**IN THE MATTER OF AN APPLICATION TO
AN BORD PLEANALA**

**For Approval of the Railway (Metrolink – Estuary to Charlemont via
Dublin Airport) Order [2022]**

ABP-314724-22

Schedule of Errata

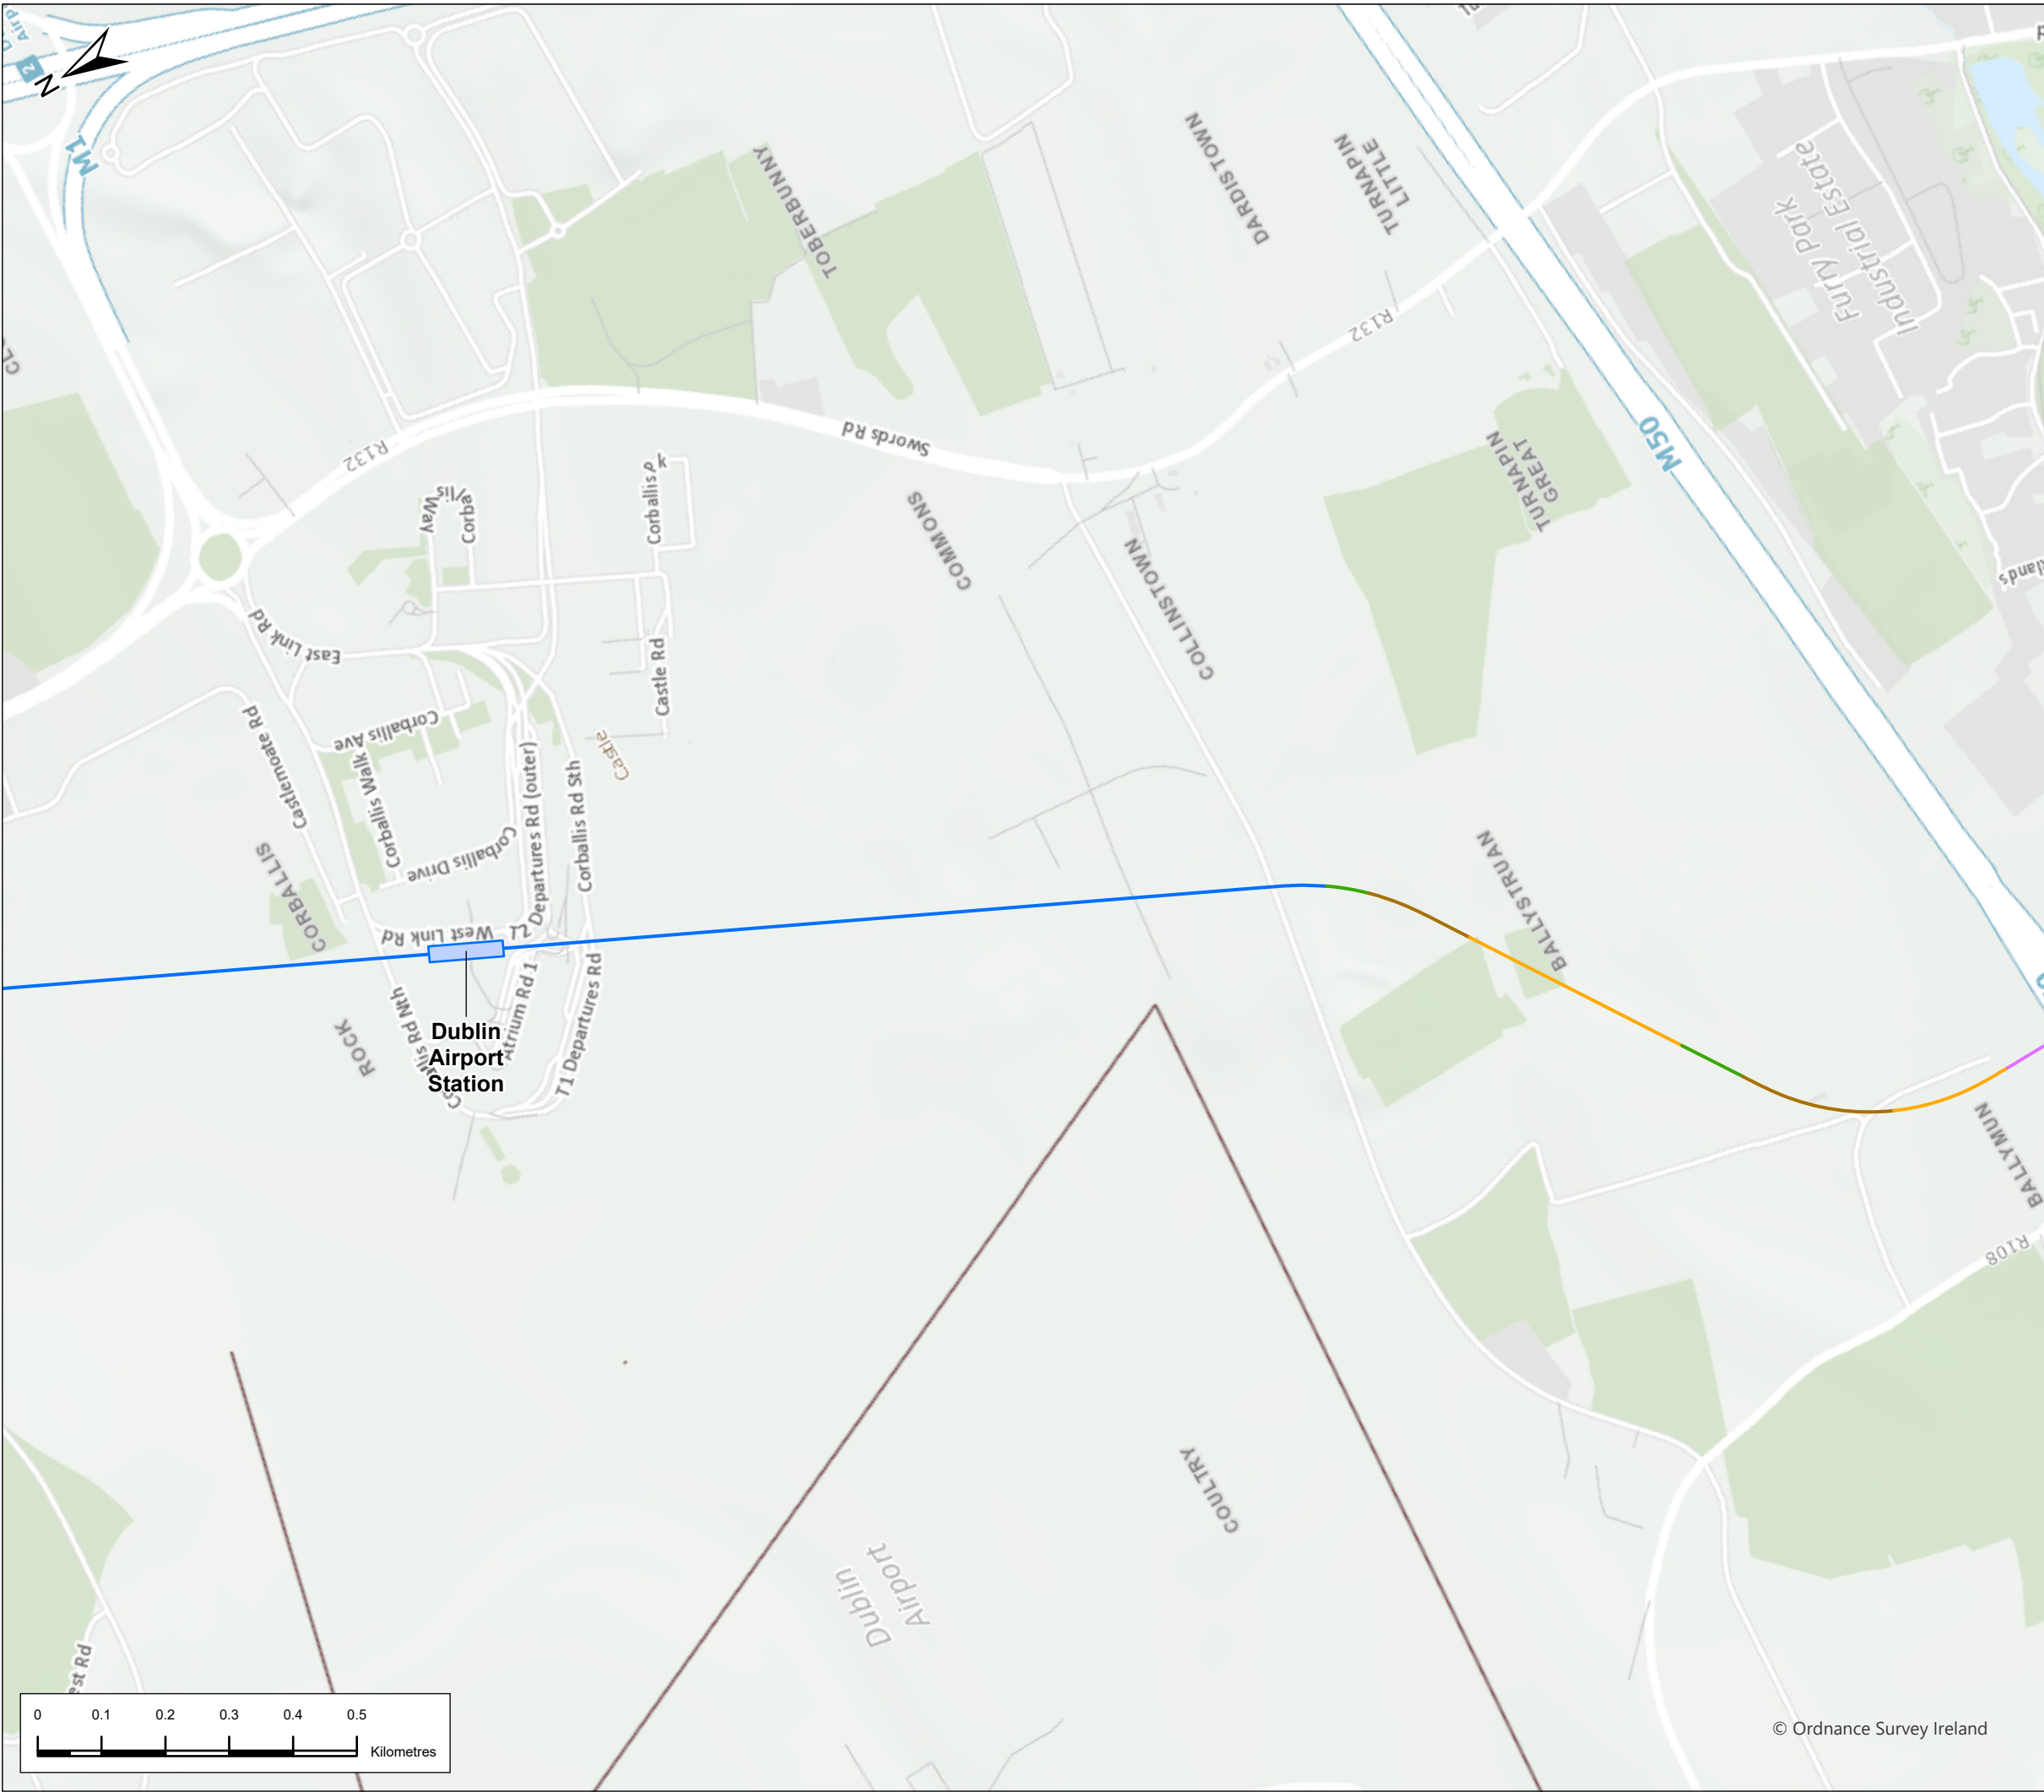
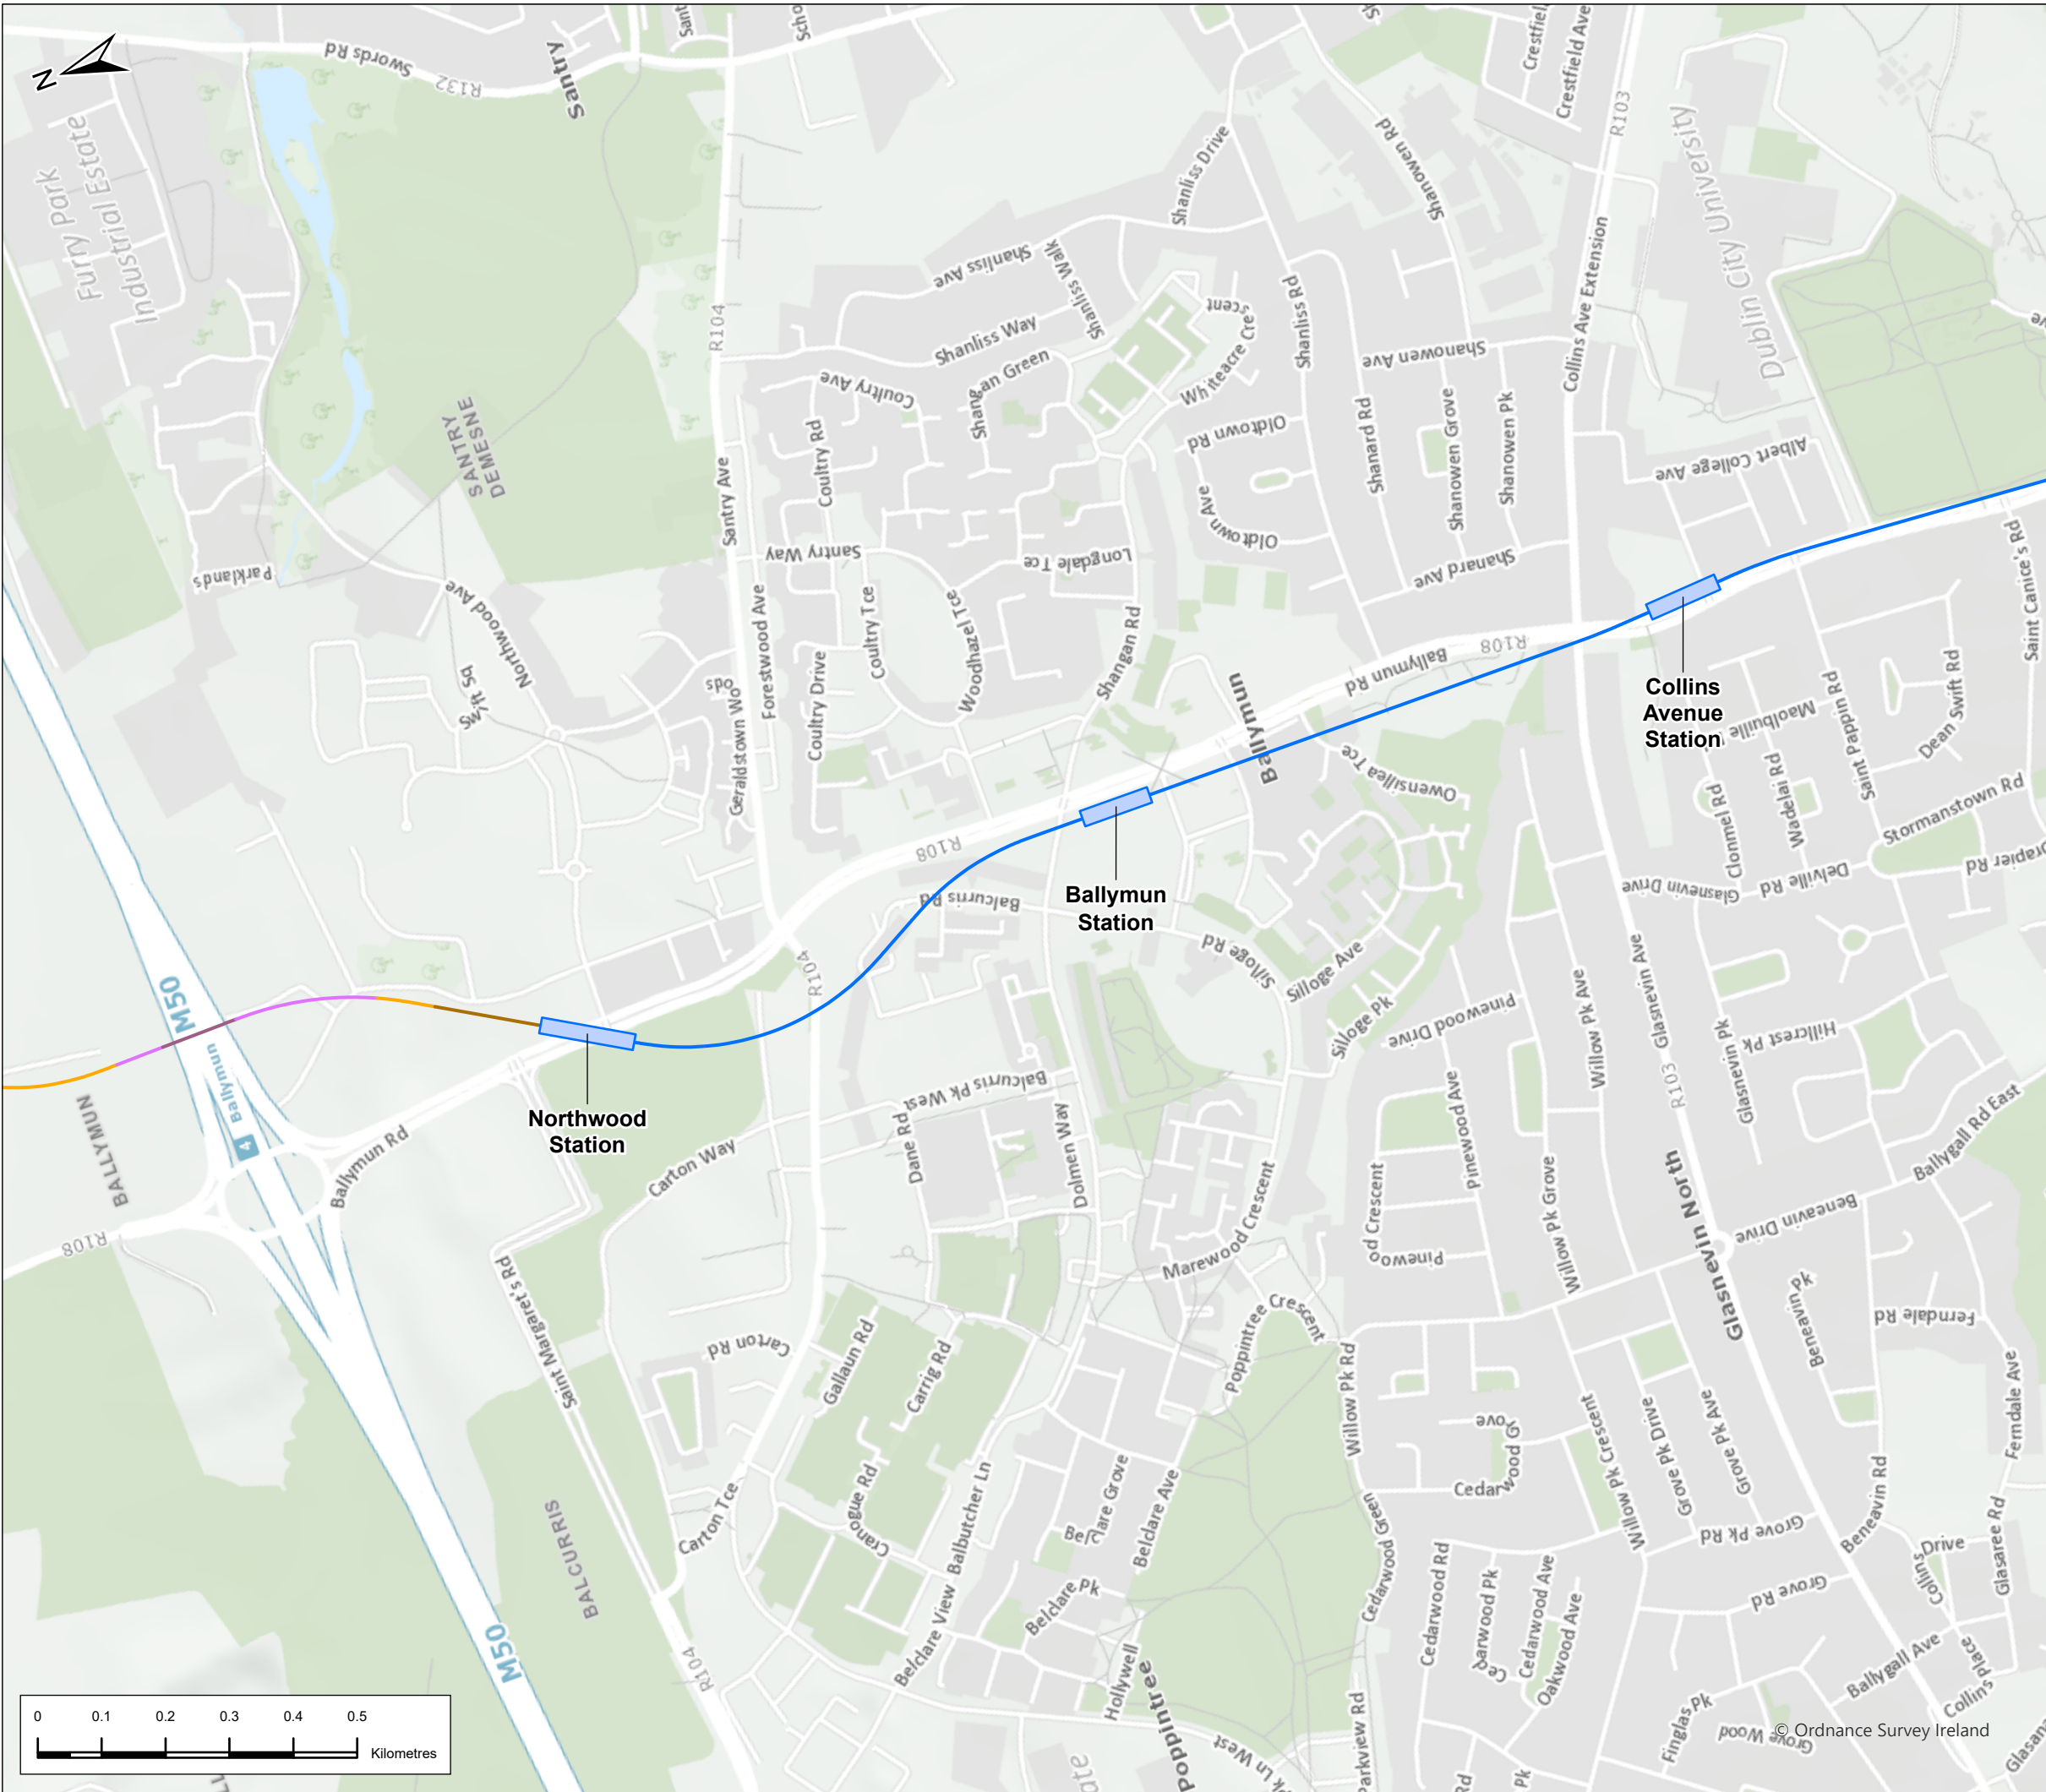
37.	EIAR Chapter 14 Groundborne Noise and Vibration	n/a	n/a	Additional Figure, showing proposed locations for Floating Slab Track	Additional Figure, showing proposed locations for Floating Slab Track. Please refer to Appendix 12 Updated and Additional GBNV Figures.
